*Tijeras Heights  
Subdivison*

Subject: Test Turnkey Project Work Authorization #T-27  
TIJERAS HEIGHTS SUBDIVISION

Re: Drainage Plan for Tijeras Heights Subdivision

RE: Tijeras Heights

FIGURE 3

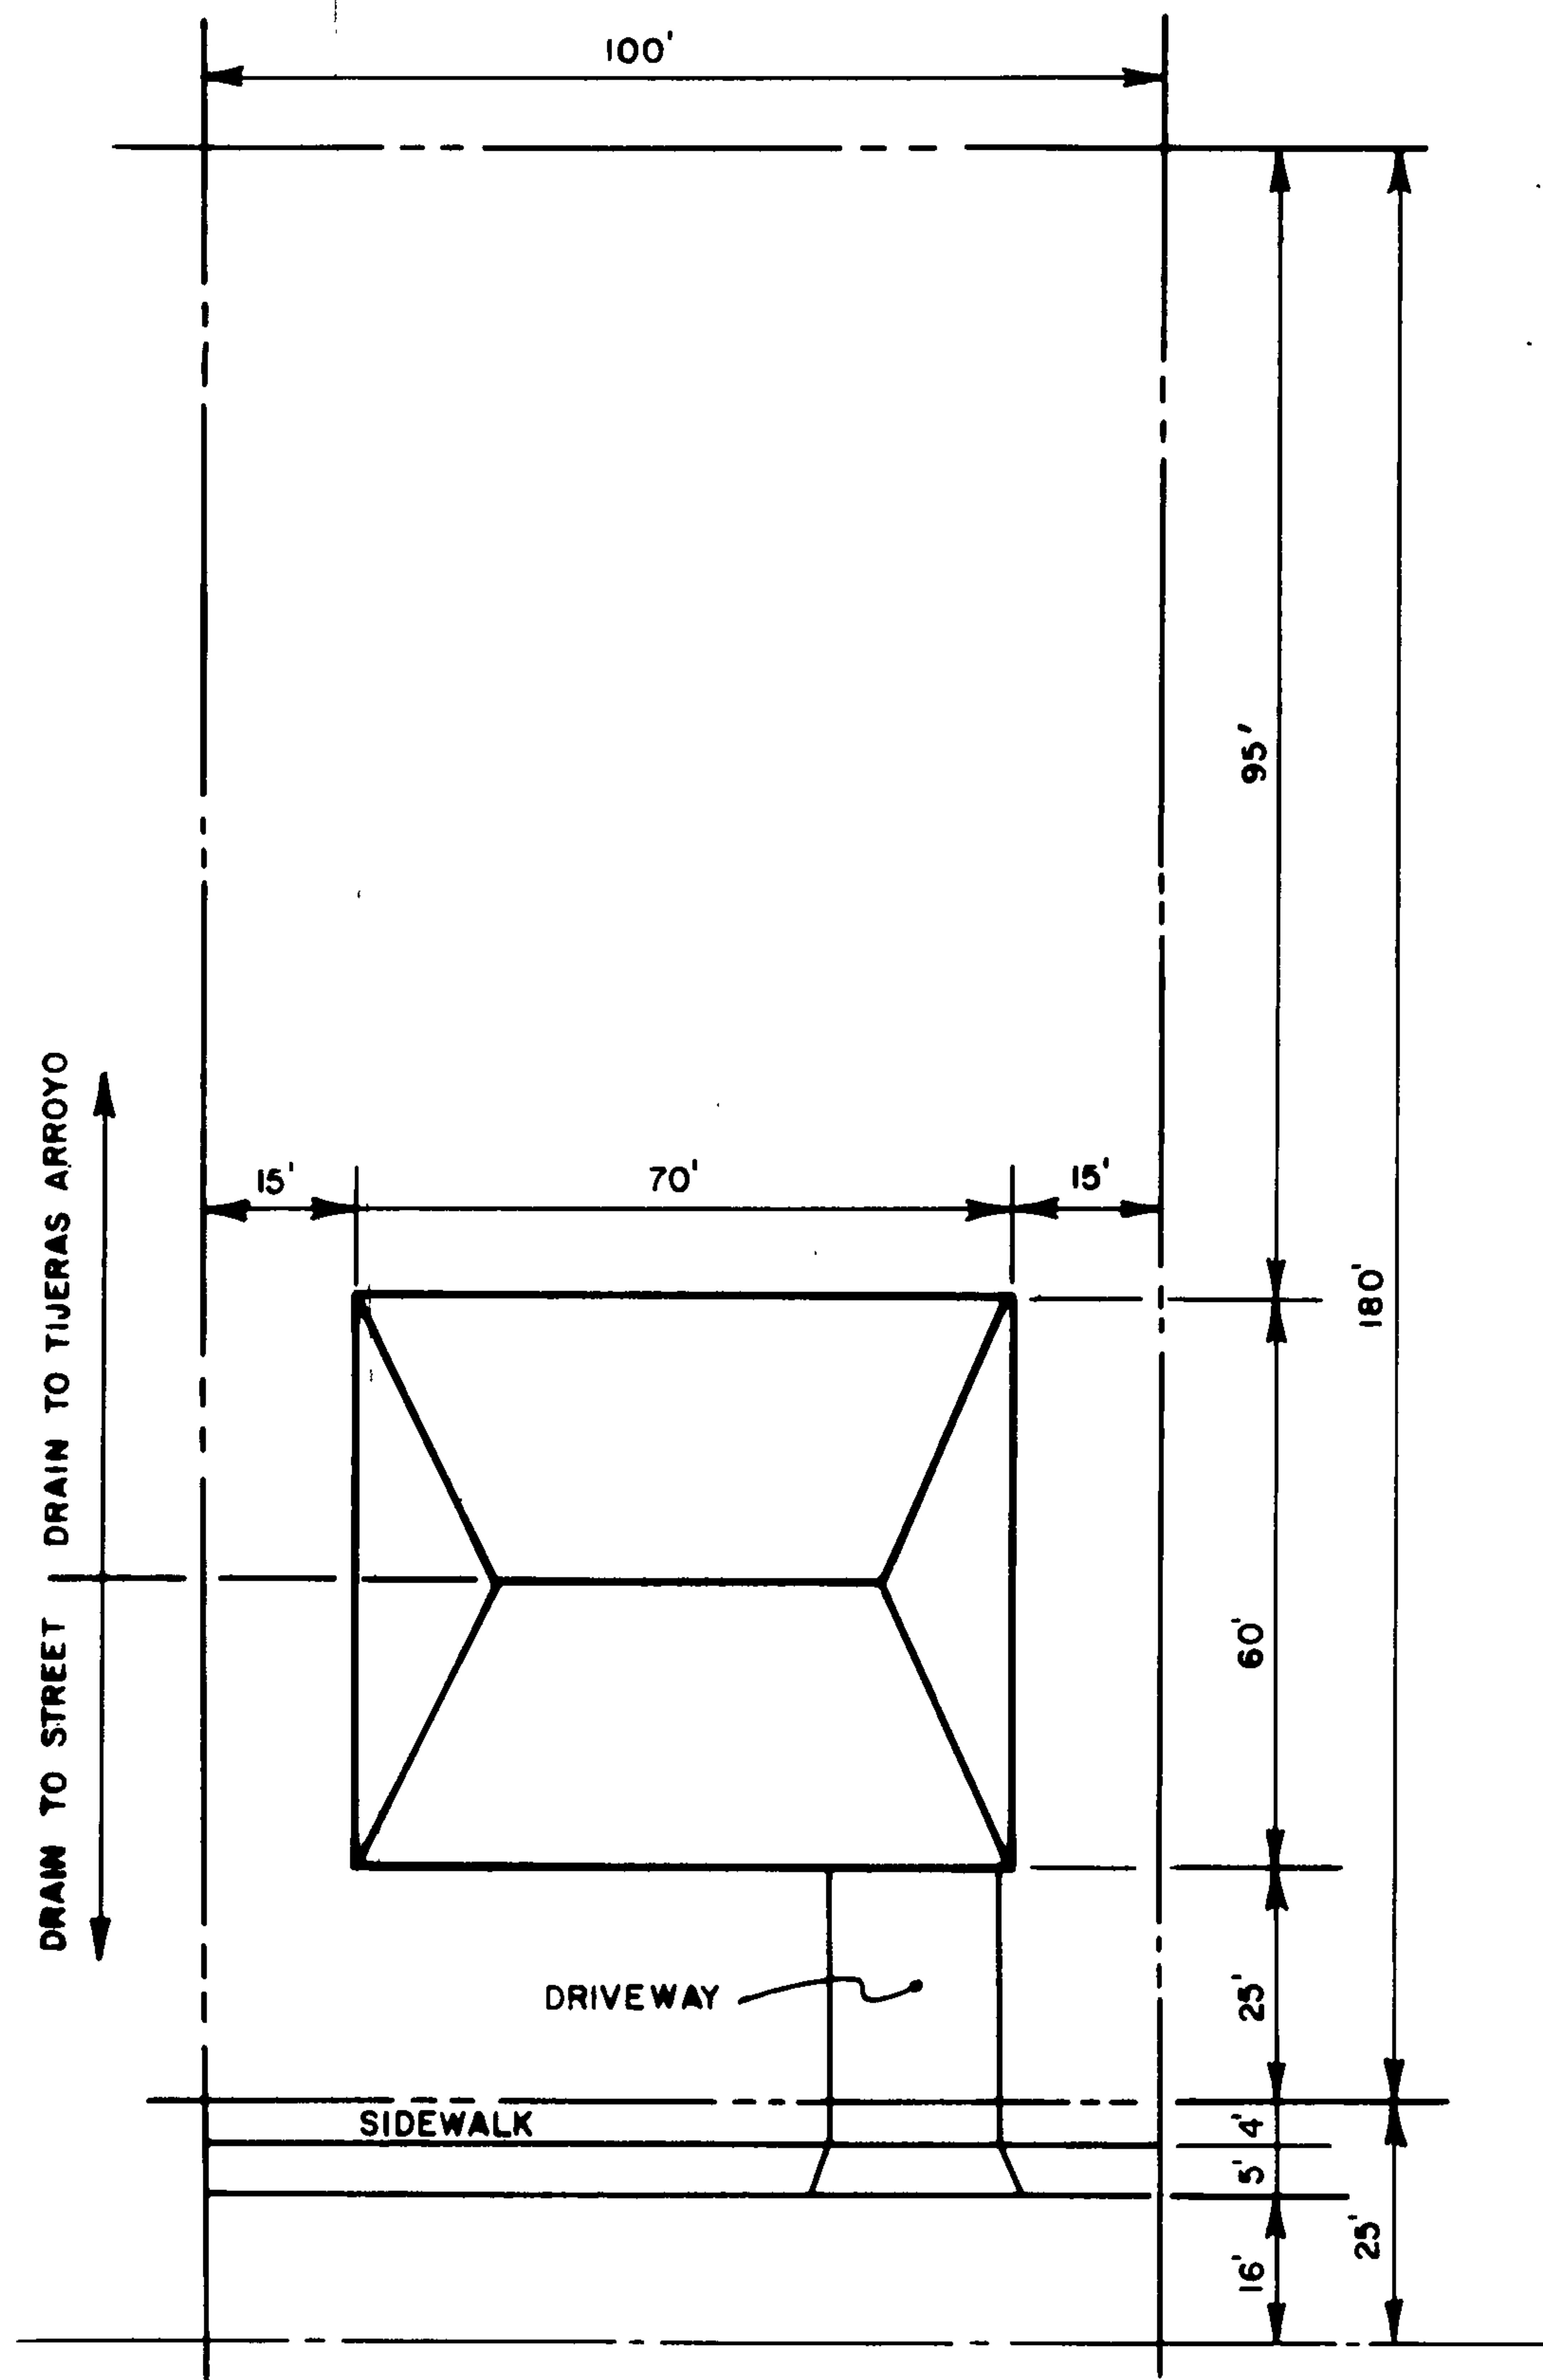
The drainage provision for Tijeras Heights Subdivision are generally acceptable except for the recommendation of allowing the runoff from the rear lots to flow over the embankment and directly into the Tijeras Arroyo. The discharge of the runoff into the Arroyo is not objectionable in itself, rather the possibility of gullying and erosion of the steep bank. For instance as shown on Figure 4 of the drainage report Lots 1,2,5,6 & 18 appear to be particularly susceptible to damages. I would therefore like to receive an addendum indicating a positive method of control of the potential erosion problem.

1. A note will be placed on the final plat stating - "All front yards and roofs shall drain to Piru Blvd. and drainage from rear yards shall not form a concentrated discharge but shall remain as sheet flow when draining to the arroyo".
2. The developer will not dedicate the flood plain to AMAFCA at this time.
3. The developer intends to retain the bank of the arroyo as open space.
4. AMAFCA concurs with the drainage plan as submitted and modified herein.

Goldberg · Mann & Associates Engineers-Planners 911 Pennsylvania N.E. Albuquerque, New Mexico 87110	NO.	DATE	BY	REVISIONS	DESIGNED BY: S.C.	JOB NO. 0813	ENERDYNE CORPORATION TIJERAS HEIGHTS SUBDIVISION	DRAINAGE PLAN	FILE NO.
					DRAWN BY: B.G.	DATE: MAY 1978			FIGURE 4
					APPROVED: T.M.

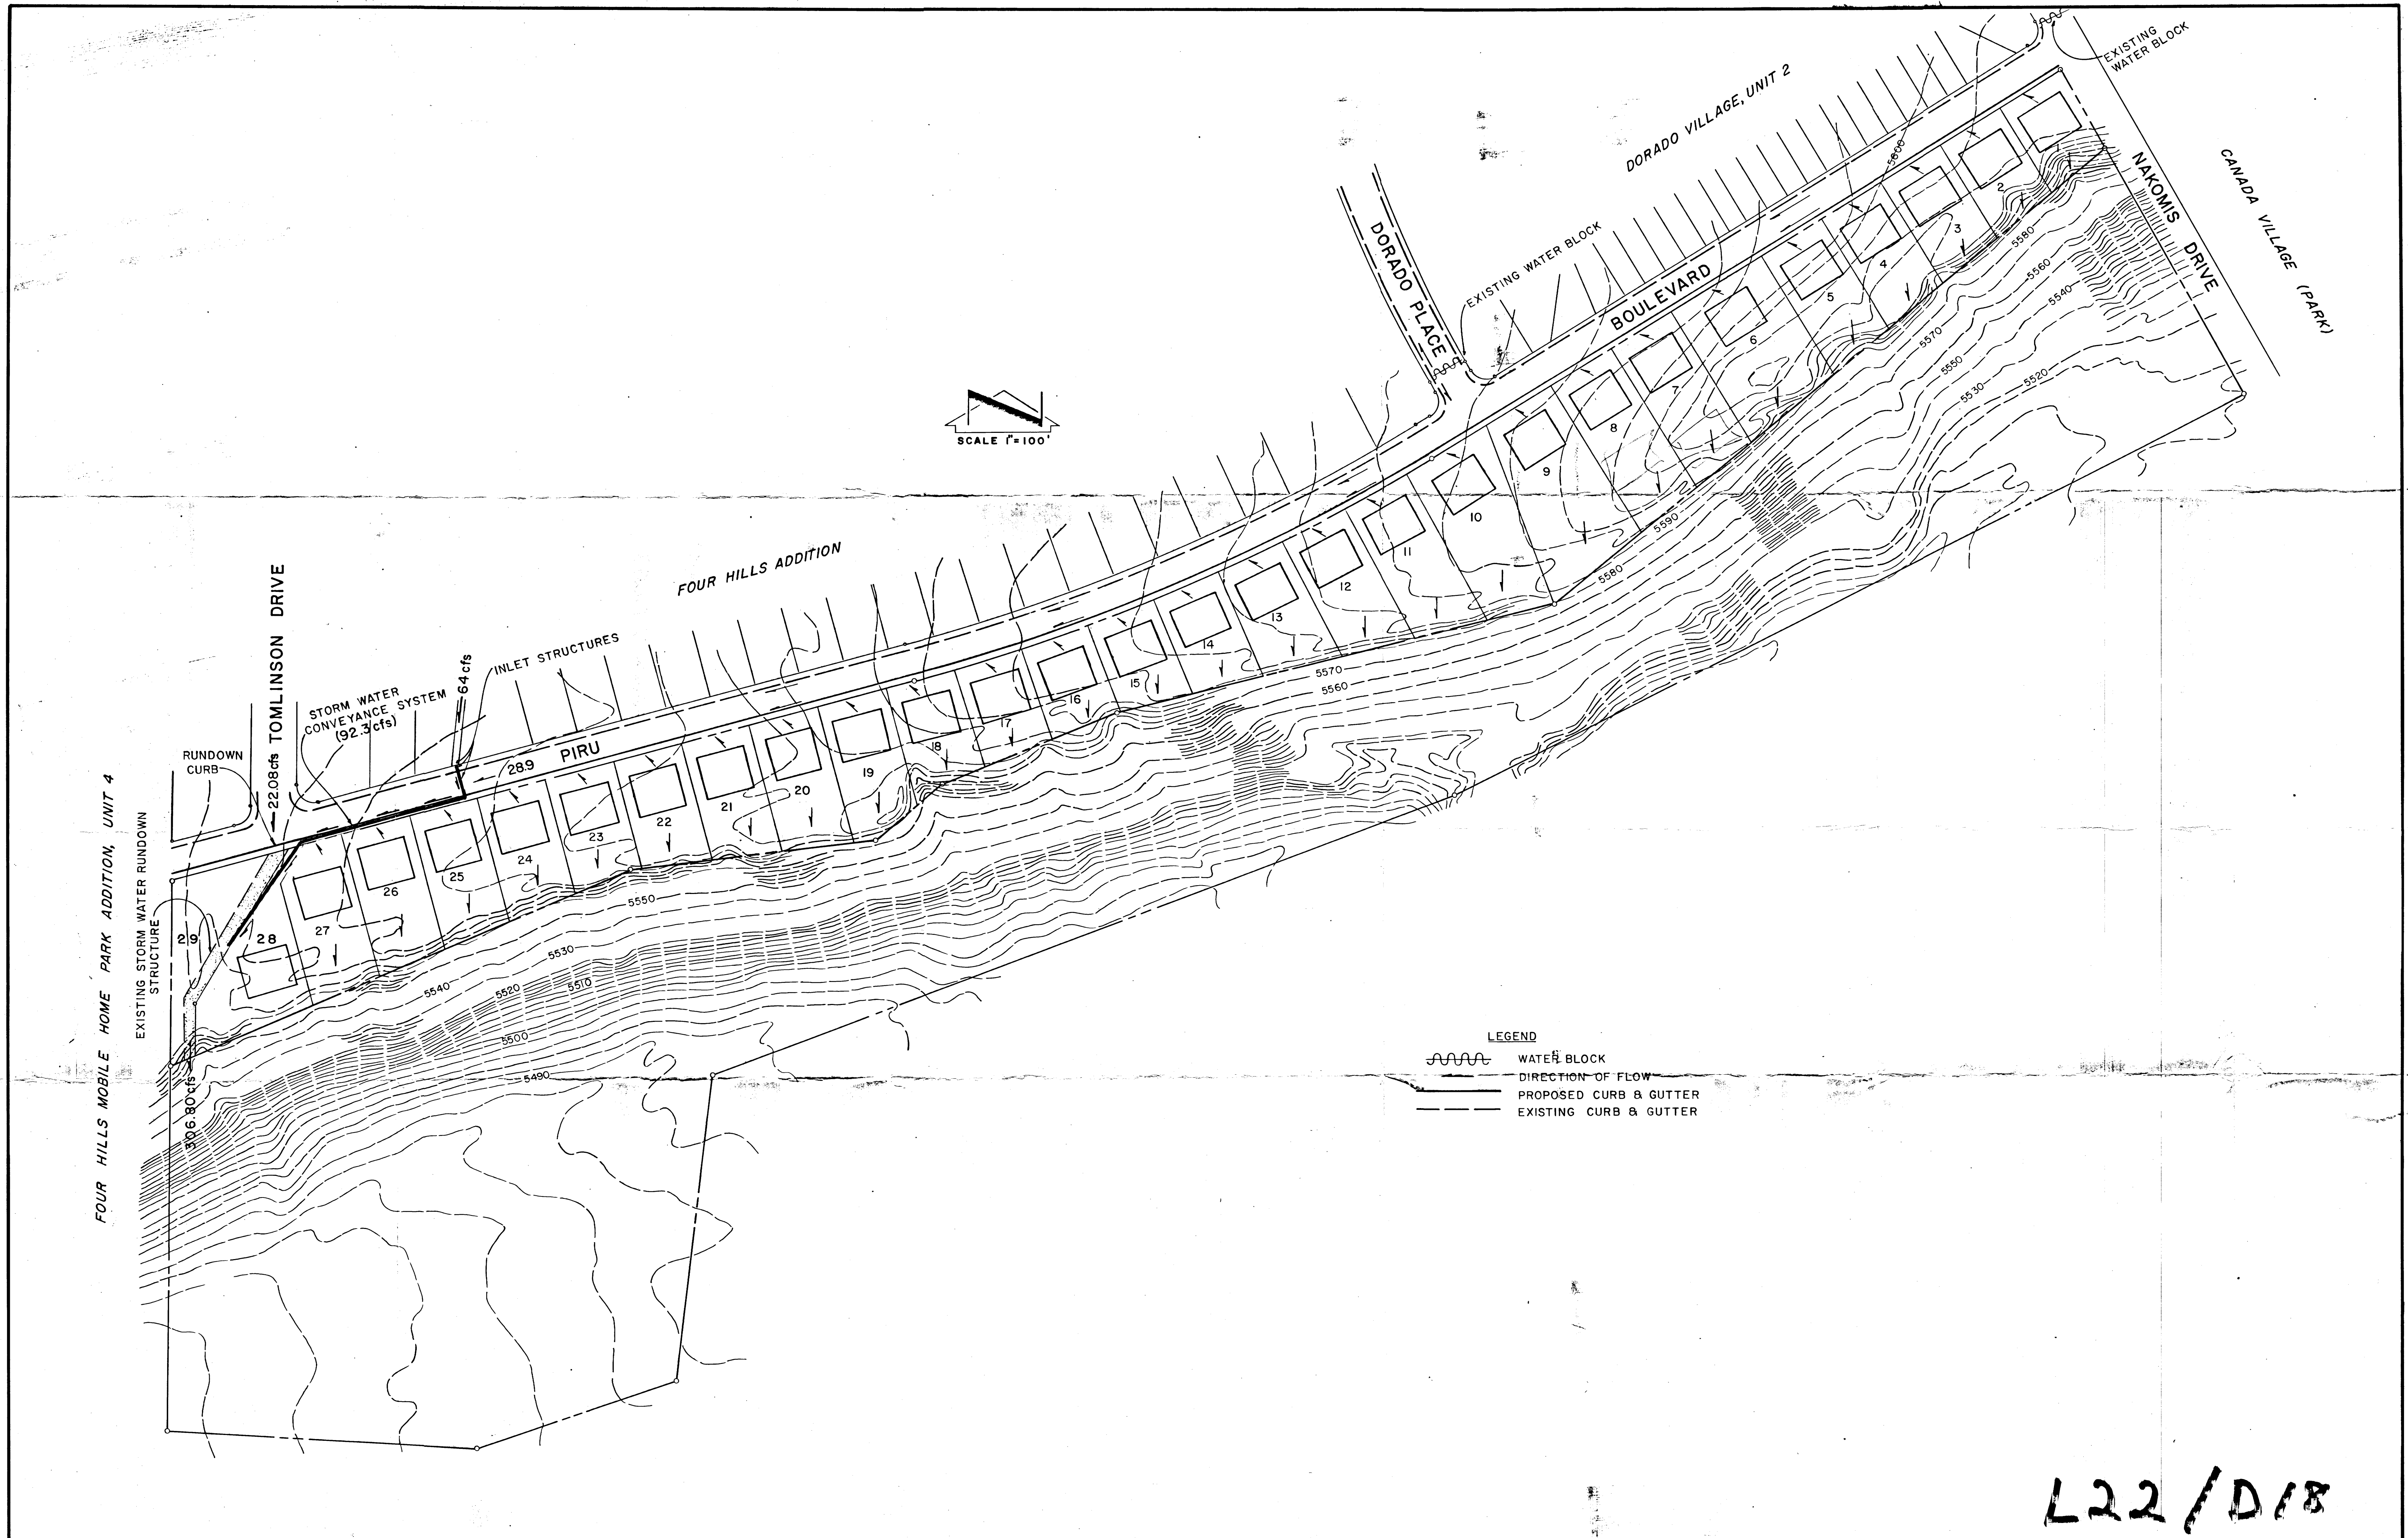
Please define also the status of the southern part of the property which covers the slope of the Tijeras Canyon Arroyo and part of the channel.
